CITY OF ALBUQUERQUE

**Re: Dunkin Drive-Through/ Central Coffee Shop and Retail Development
Traffic Impact Study (K09D054)**
DRAFT Study dated 5-22-24
Via email laboona@kloainc.com

The subject Traffic Impact Study (Study) draft received on May 23, 2024 , has been reviewed by the City of Albuquerque Planning Development Transportation Section. The City has the following comments to be addressed.

Site Plan

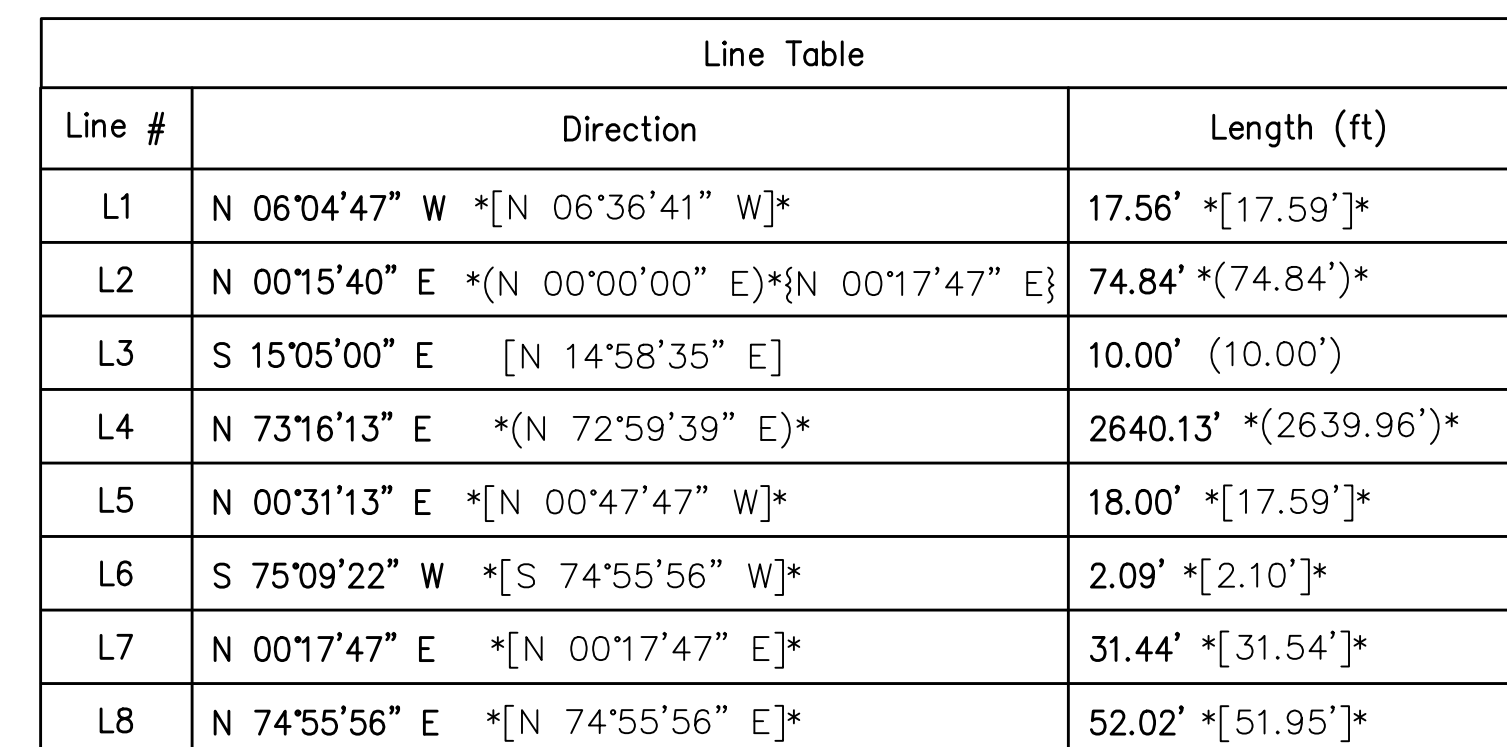
- i. The driveway on 98th St was proposed right in/right-out too close to Central Ave. and is in the right-turn lane onto Central Ave.
 - ii. The driveway on Central Ave is an acceptable distance from 98th St.

Site Plan

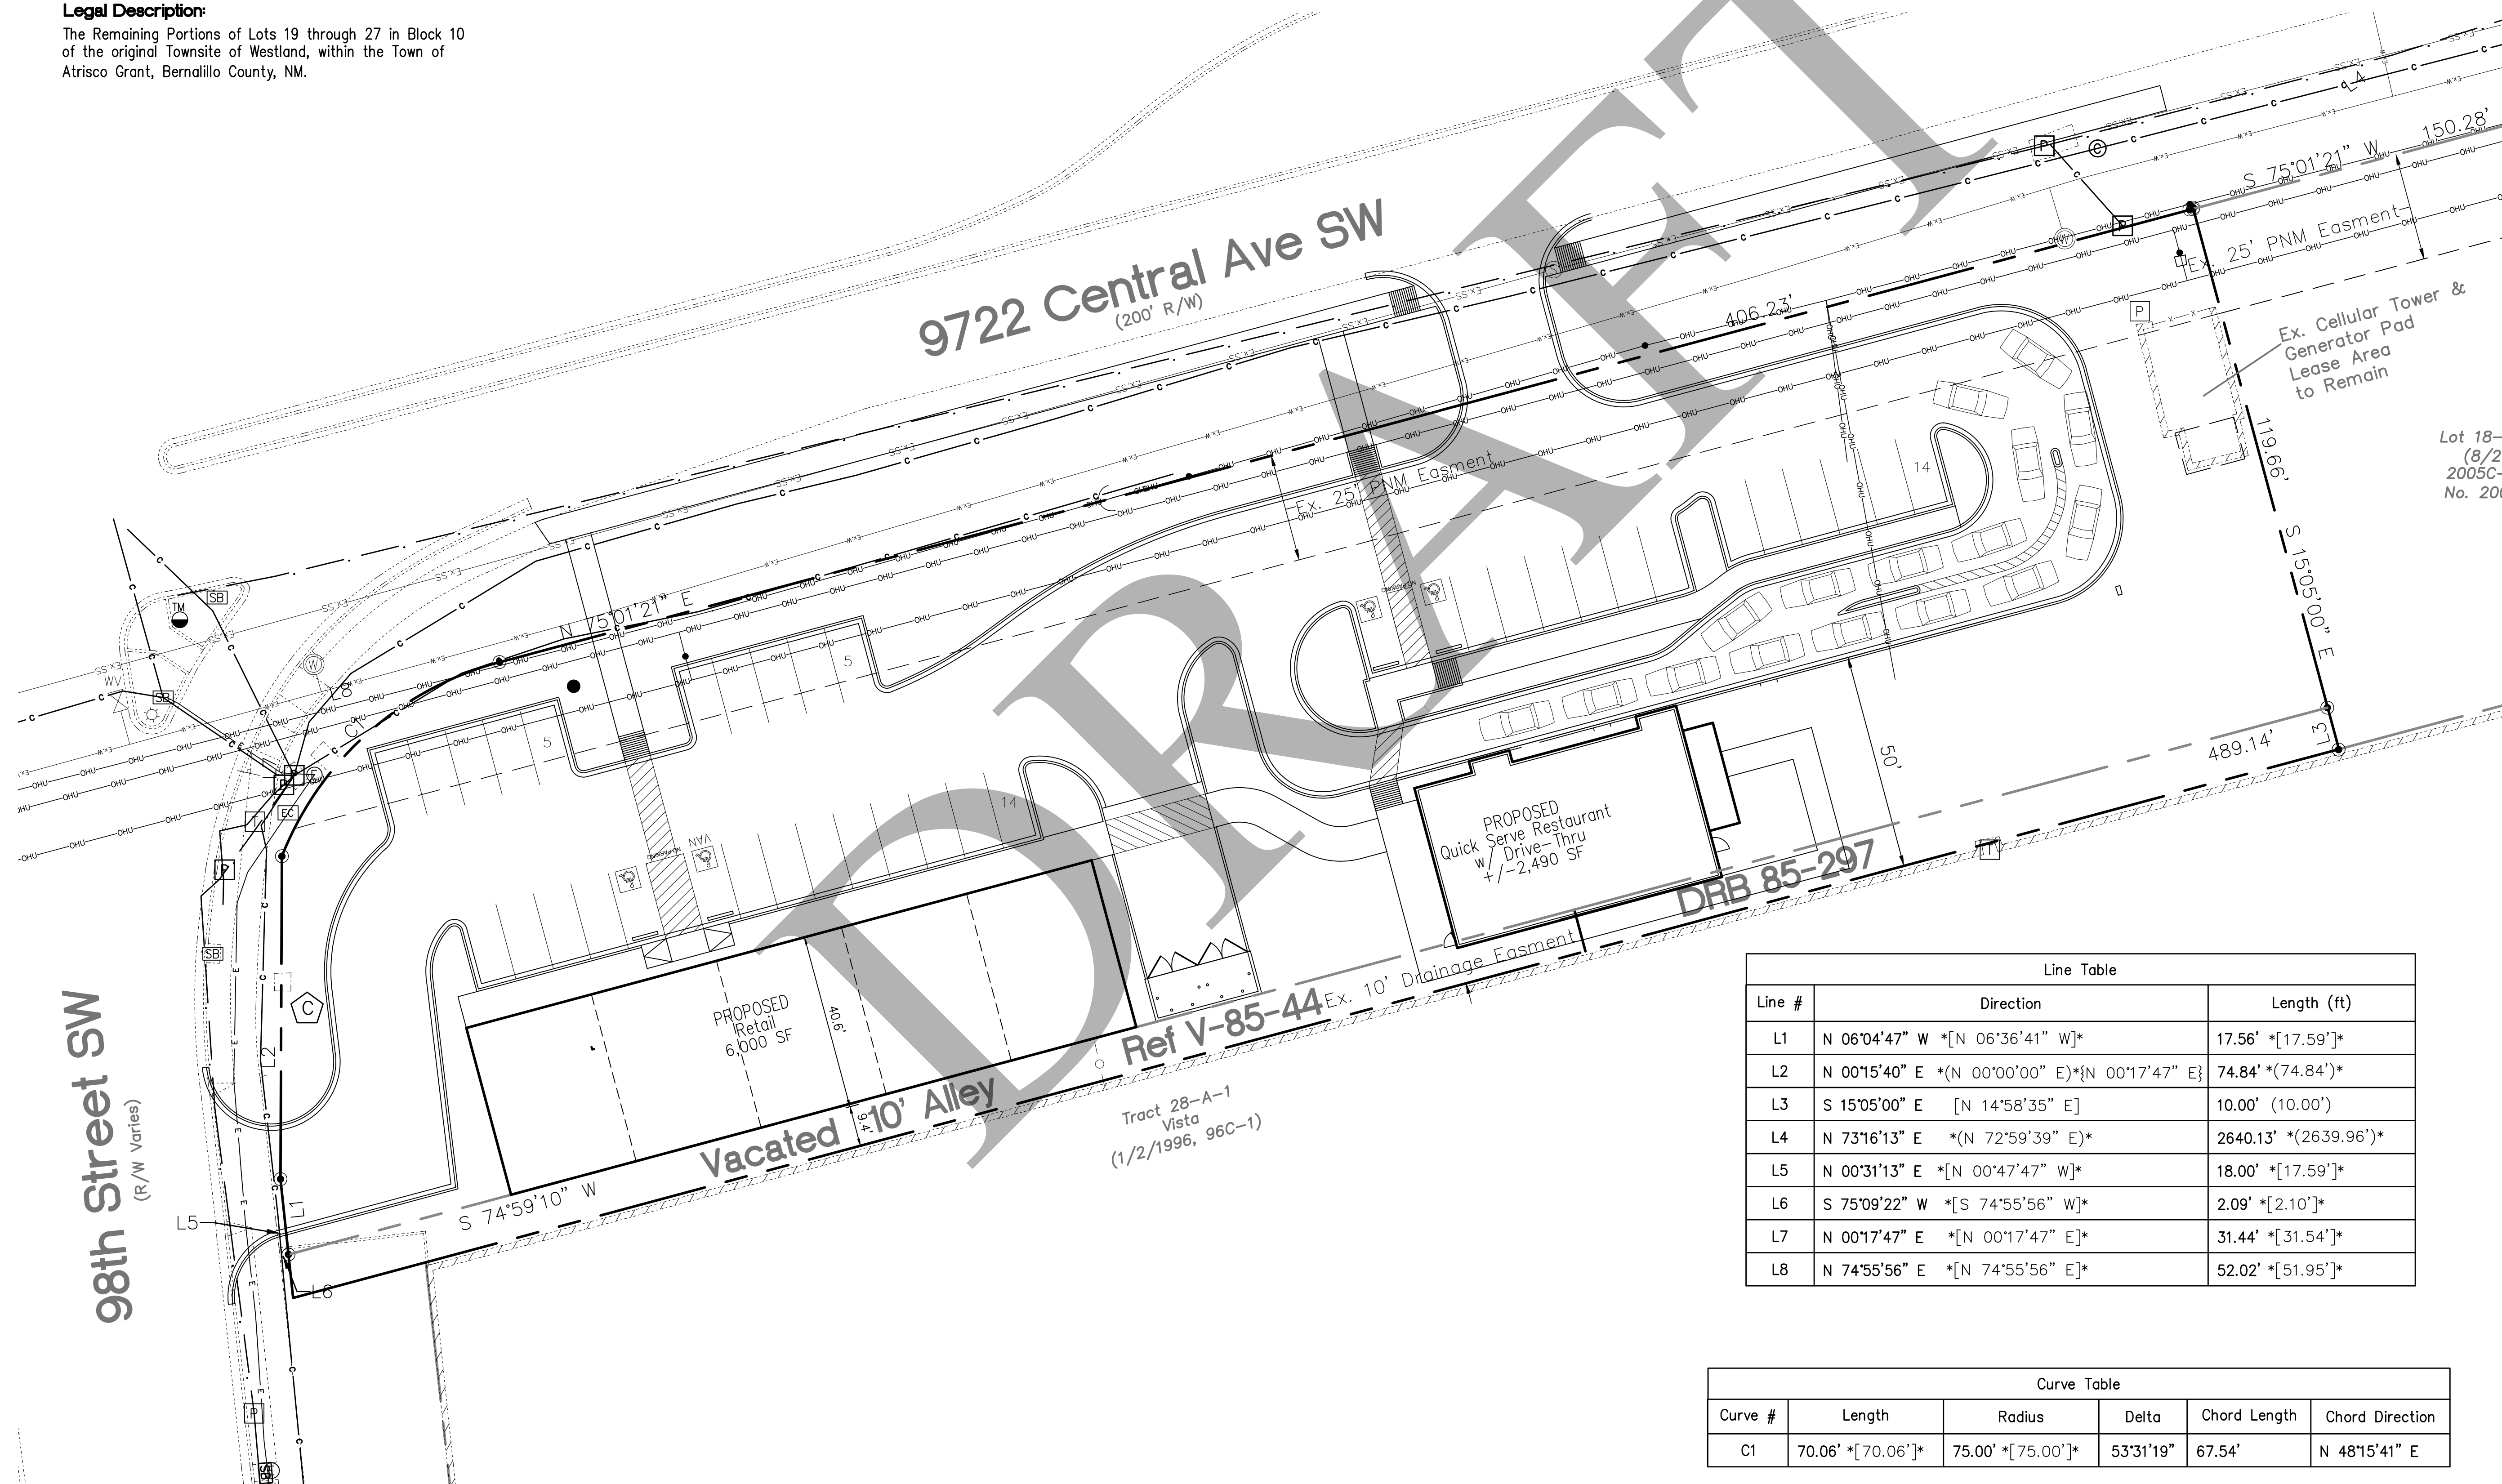
- b. Second Submittal- KLOA February 2024
 - i. The driveway on 98th St was proposed right-in/right-out and too close to Central Ave and is in the right-turn lane onto Central Ave.

- ii. Swapped location of Dunkin and the strip retail building.
 - iii. The driveway on Central Ave. appears to be an acceptable distance from 98th St.

- i. The driveway on 98th St proposed right-in only, but it is still too close to Central Ave and in right-turn lane onto Central Ave. Location is not approved by City Engineer.

- 1. The driveway is too close to the intersection with 98th St
 - 2. Presents a conflict, wherein, a driver preparing to leave the west driveway sees a driver entering the short decel lane on eastbound Central Ave. Assuming they will turn into the west driveway, the driver enters the acceleration lane to enter Central Ave, however, the driver in the decel lane wanted to go to Dunkin so they don't turn into the west driveway.

- a. One driveway on Central Ave in location of the KLOA Study dated February 26, 2024.
- b. A Right-in/right-out driveway on 98th would be a possible solution to minimize conflicts at Central and Westland Rd provided the driveway is south of the right turn lane on 98th st, approx. 290 ft. Driveway to be maintained by the Owner.

A right-in only on 98th St, with the driveway approx., 290 ft south of Central Ave and a median U-turn in the median between Westland Rd and 94th St. Driveway to be maintained by the City.
